Sea Link Energy Cable

**Appendix E6 to the Natural England Deadline 6 Submission
Natural England's Intertidal and Benthic Ecology Advice**

Planning Inspectorate Reference EN020026

13th April 2026

Plate 1.2 Port Areas of Safeguarded Water Depth

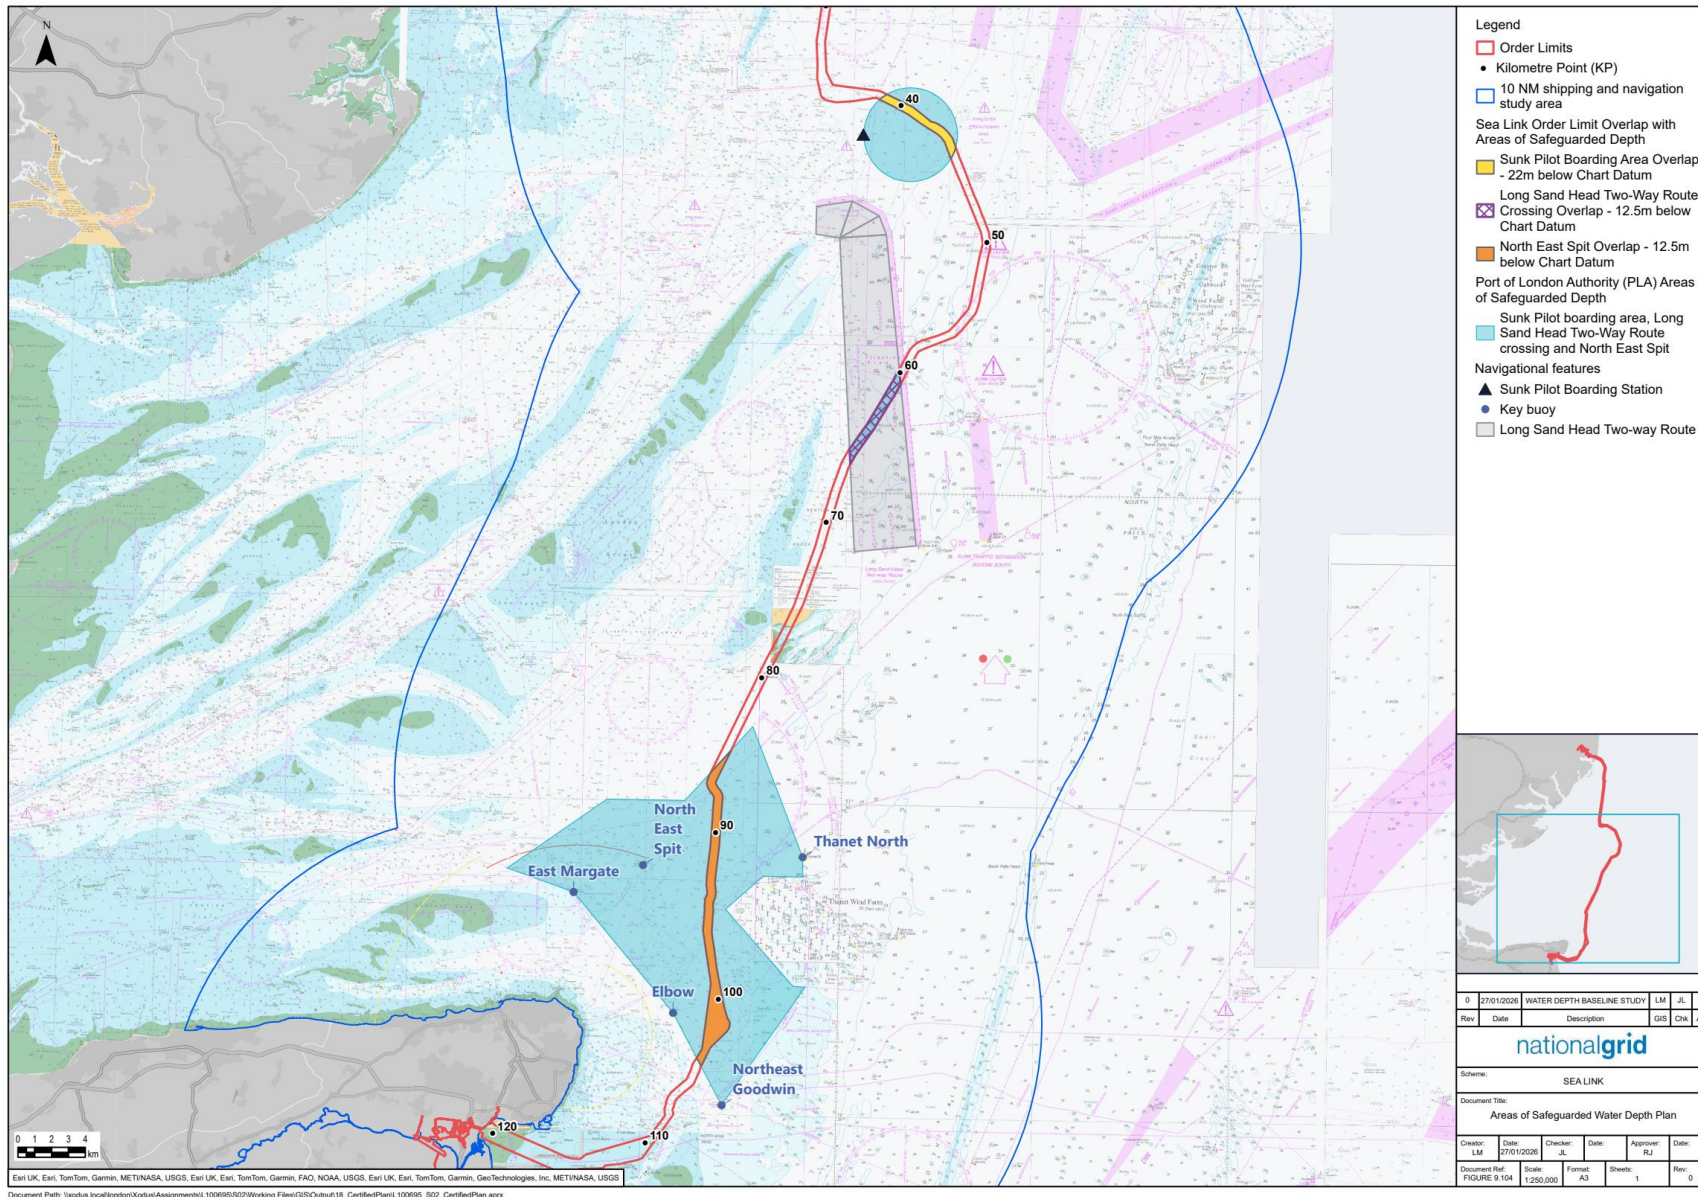
Document reviewed: [REP5-139] – 9.126 Areas of Safeguarded Water Depth - Consideration of Additional Installation Requirements			
NE Ref	Section	Key Concern and/or Update	Natural England’s Advice to Resolve Issue
1	Table 2.1	Natural England is concerned that sediment from sandwave levelling will be re-distributed to ensure no backfill of swept areas.	<p>Please see Table 1 Point 3 above on sandwave levelling mitigation and Natural England’s position on this.</p> <p>Please also see comments included in Appendix D6 to our Deadline 6 submissions in relation to indirect impacts to designated sites from proposed activities which are also relevant to this document</p>

Plate 5.1 Offshore scheme cable crossings and areas of rock backfill

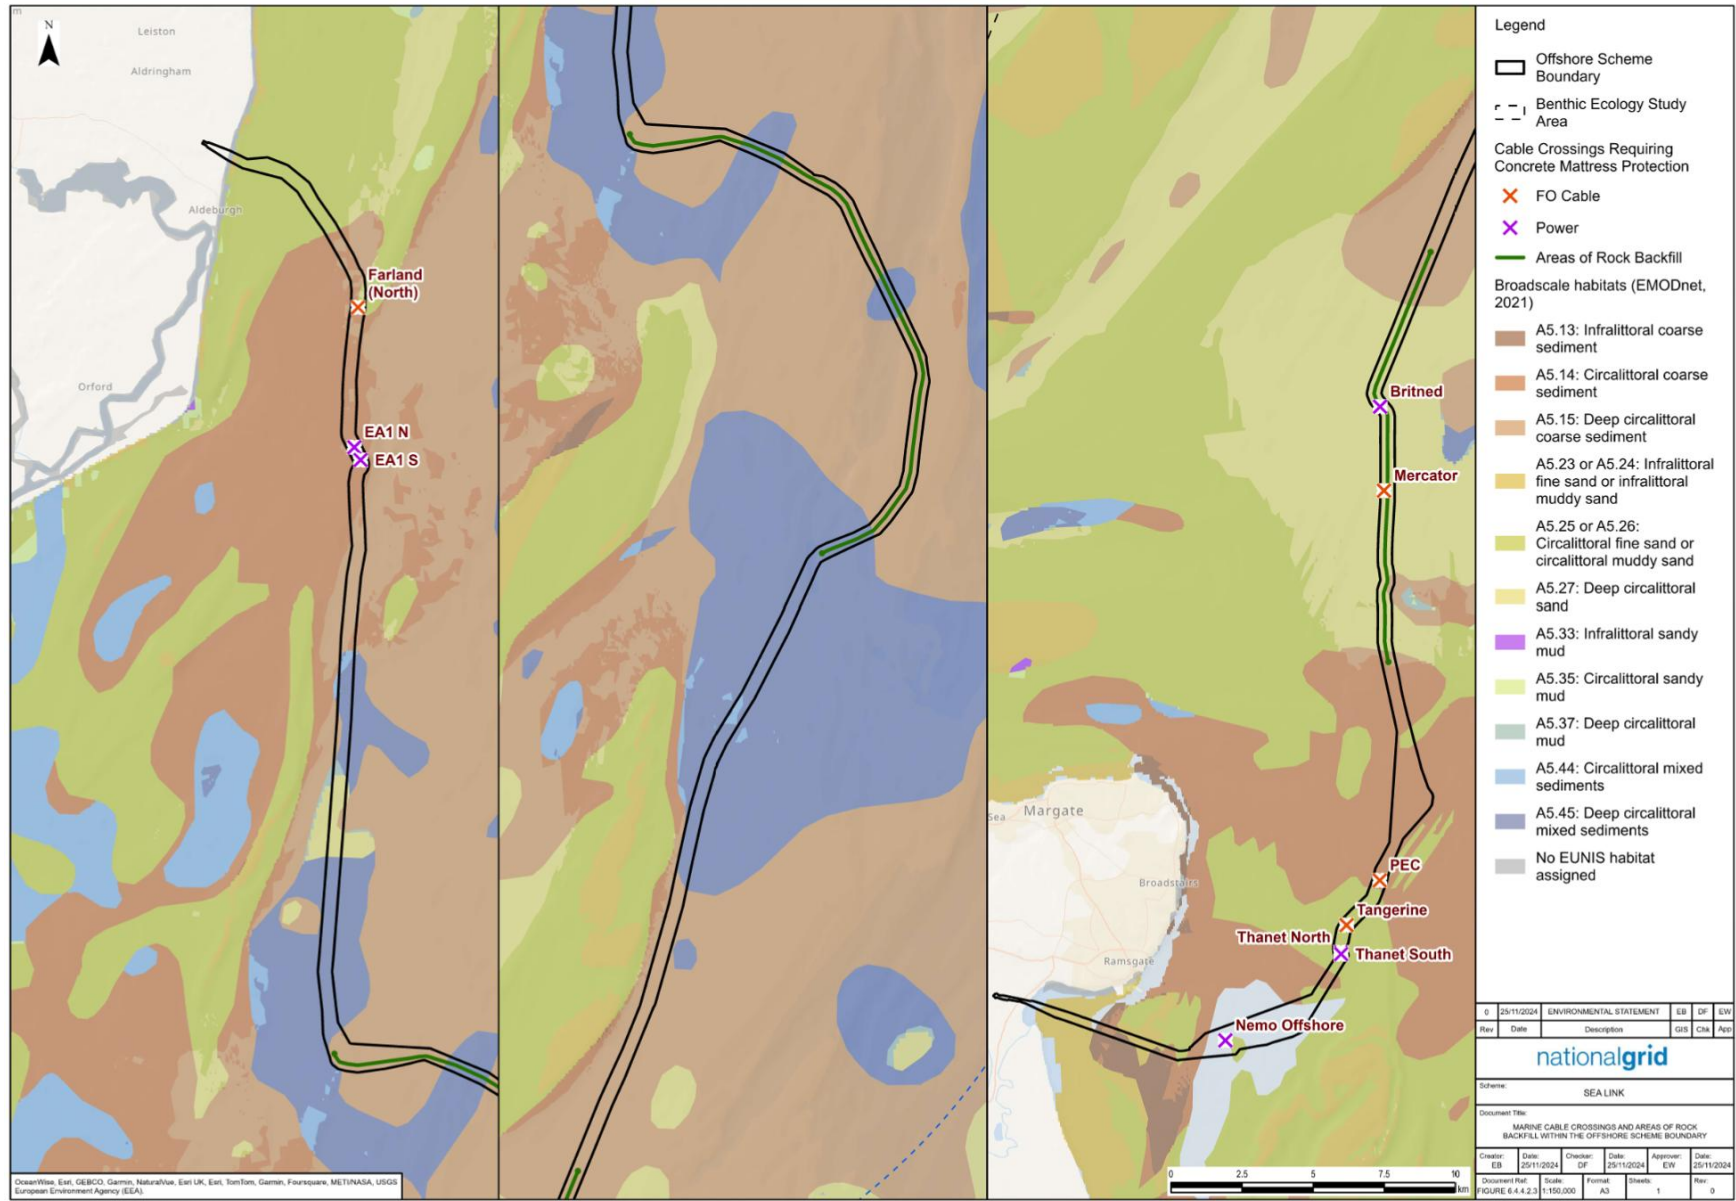
Knoll OWF has demonstrated that jack-up leg depressions have persisted and impacts have occurred for 2-10 years.	
5	5.1.4	Natural England highlights that considerable lengths of cable protection are proposed, e.g. 20km between KP38 and 58 and 15km between KP81.5 and 96.5. It is not clear if these will be continuous lengths of projection or not. It is also noted that this is greater than required for other projects.	Natural England advises that further clarity is required on the proposals and if this is just during construction. Until we have this clarification it is difficult to assess benthic and marine processes impacts.
6	5.1.5 and 5.16	Natural England notes the requirement to avoid microplastic entering the marine environment. Whilst this is welcomed it is worth noting that when considering cable protection this may not be possible at all locations. Where removability of cable protection within designated sites is paramount, in order to avoid increasing impacts during decommissioning this would currently require the use of concrete mattresses with hoops and/or rock bags. However, we do note there is now technology to make rock bags out of rock and not be reliant on bags manufactured from plastic.	Natural England advises that this is considered further in the final Cable Specification and Installation Plan (CSIP) prior to construction and that commitments to considered this then are included within the REAC.
